CITY OF ALBUQUERQUE

RE: **UNM Starbucks and Freddie's**
2550 Central SE
Grading and Drainage Plan
Request for Temp C.O. – Accepted
Engineers Stamp Date 2/22/17 (K16D075)
Certification dated: 1-10-18

ENGINEER'S SEAL	STARBUCKS/FREDDY'S	DRAWN BY WCWJ
	GRADING AND DRAINAGE PLAN	DATE 2-22-17
		21702-LAYOUT-1-16-17
DAVID SOULE P.E. #14522	 1606 CENTRAL AVENUE SE SUITE 201 ALBUQUERQUE, NM 87106 (505) 872-0999	SHEET #
		JOB # 21702

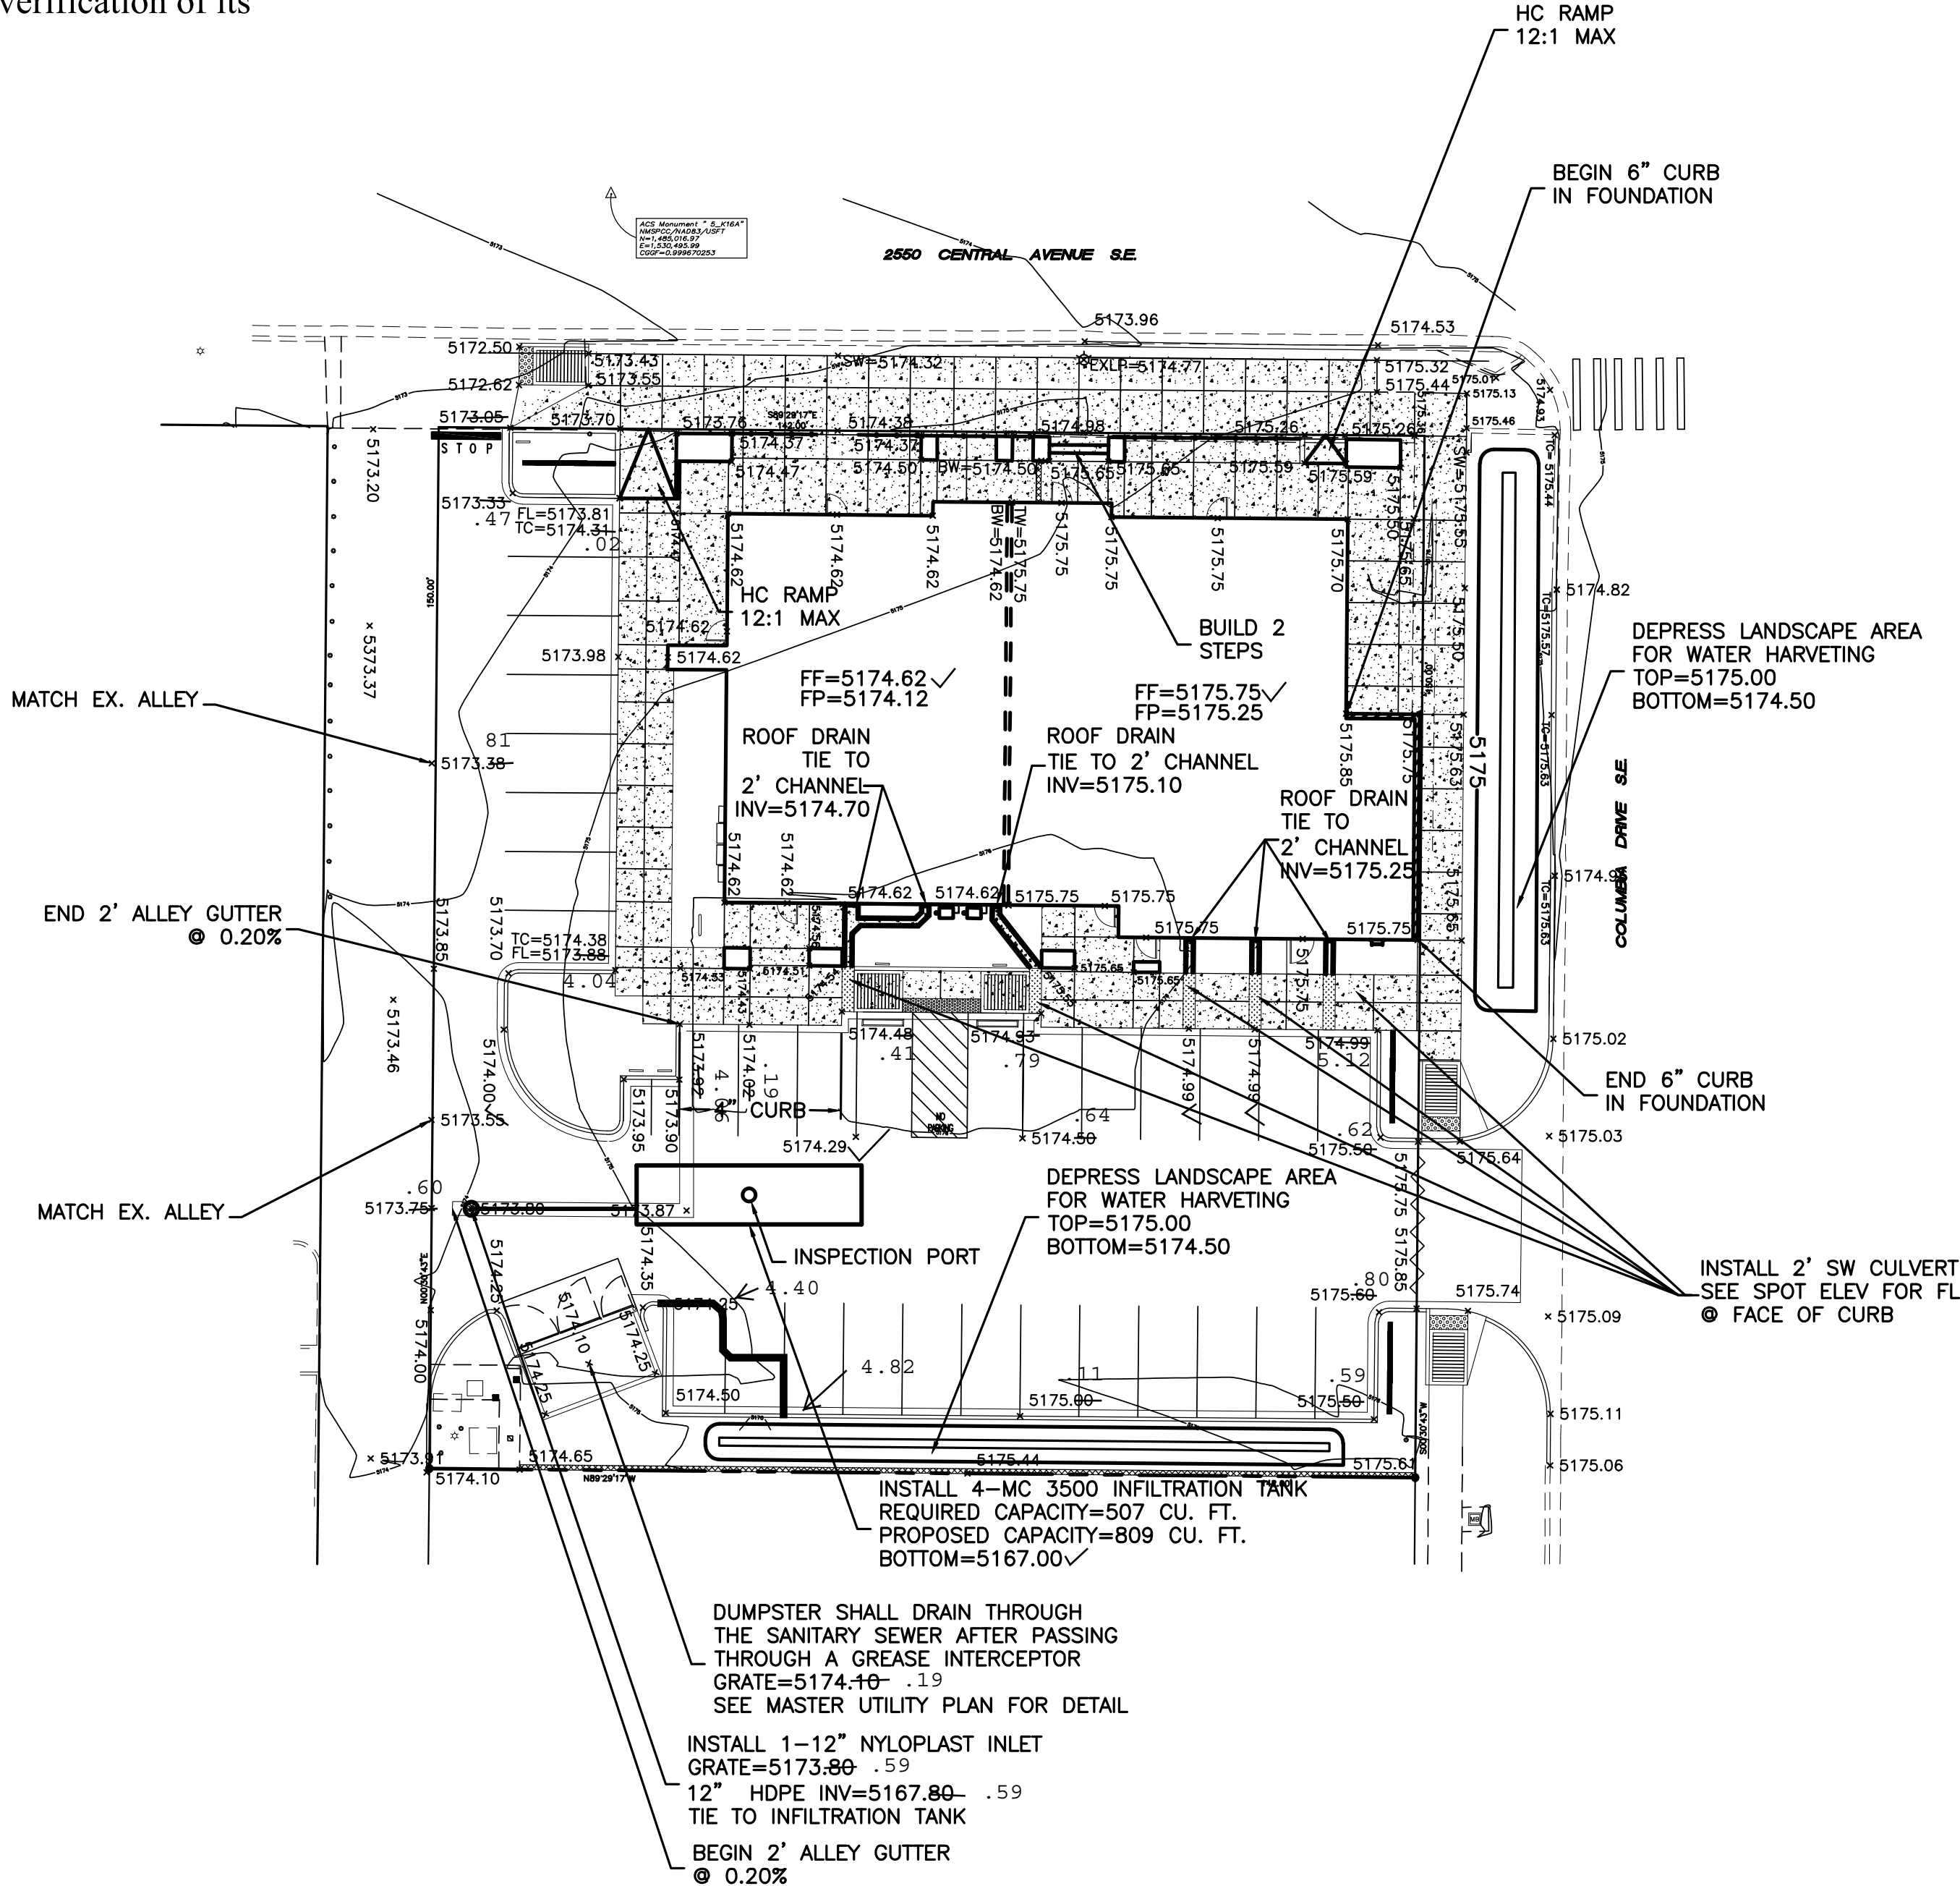
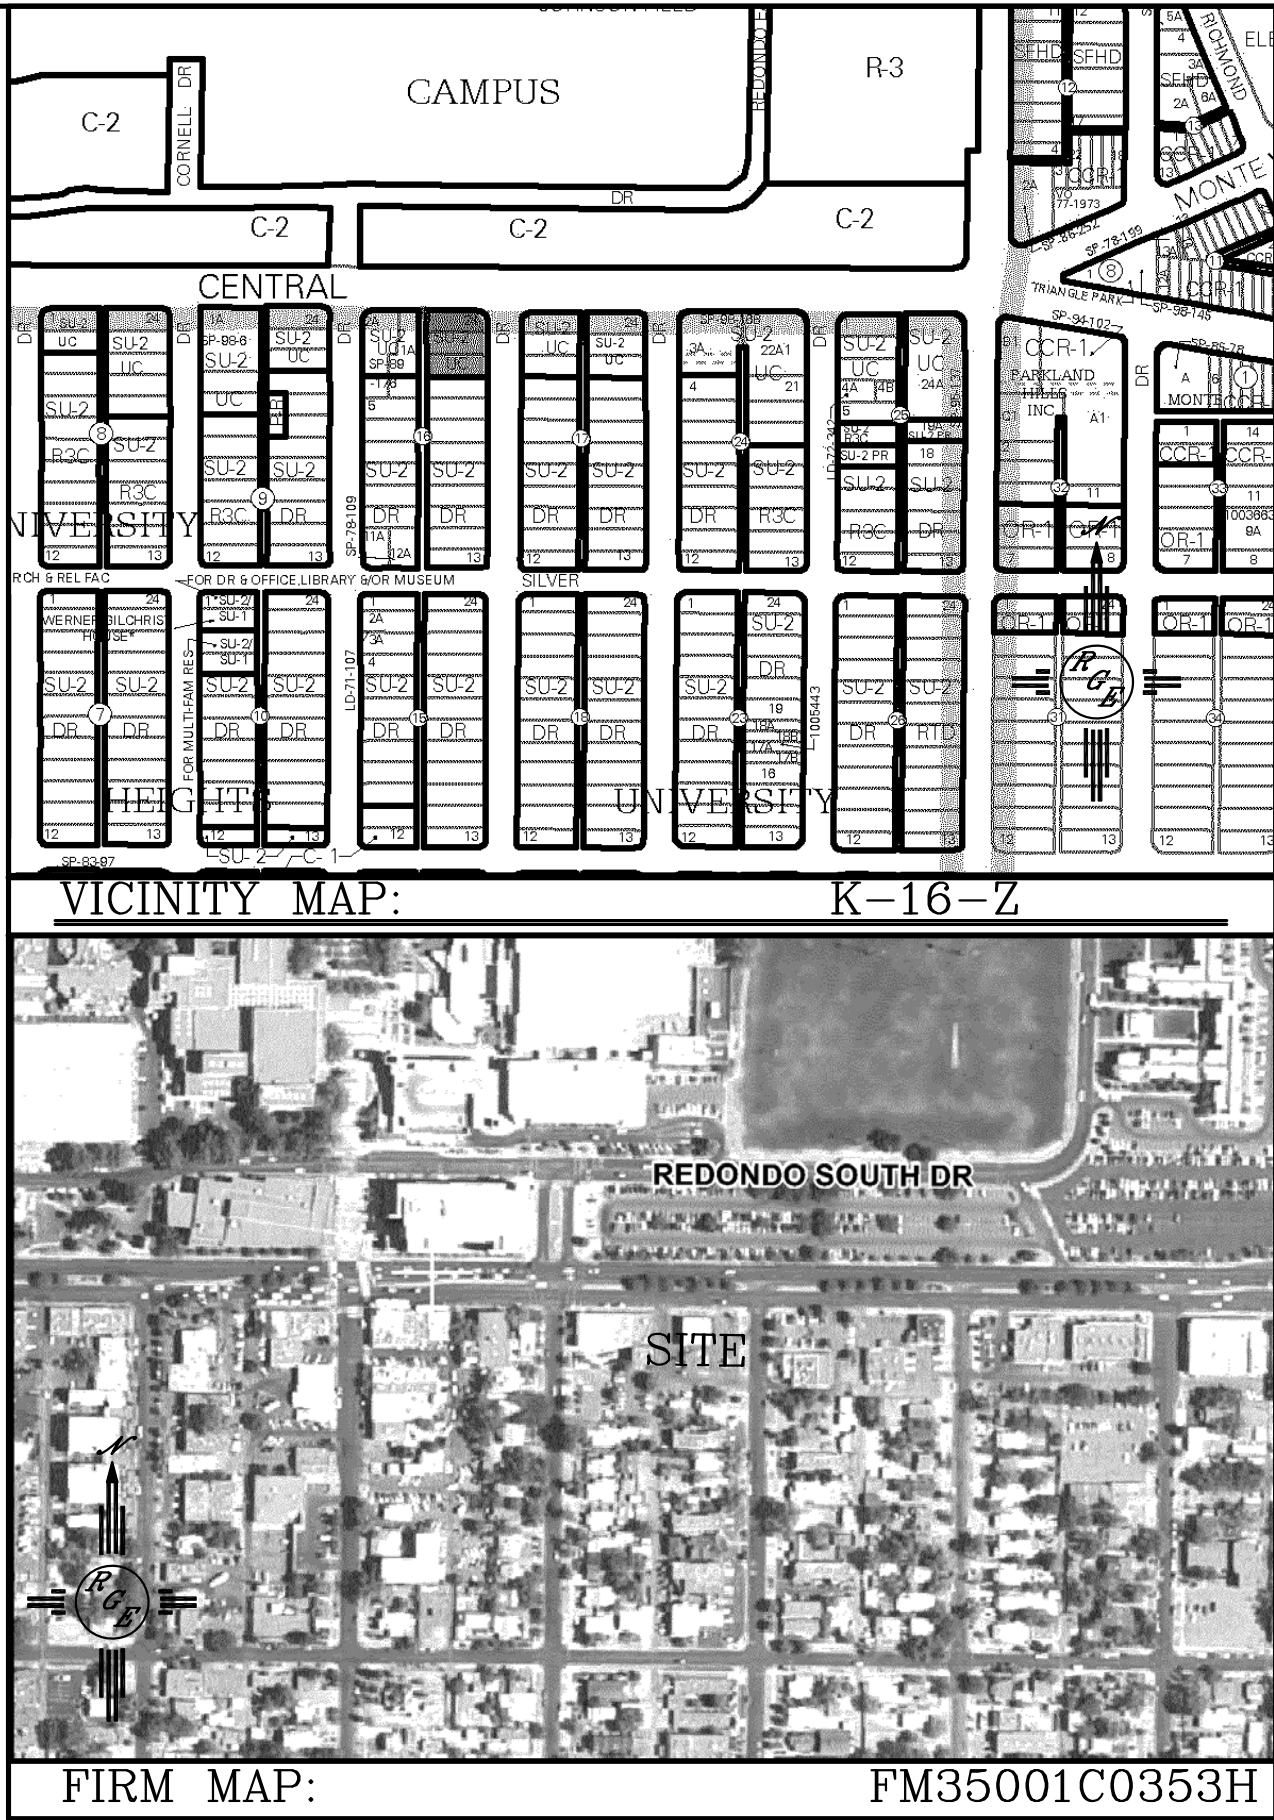
- Sidewalk culvert should be constructed per the plan.
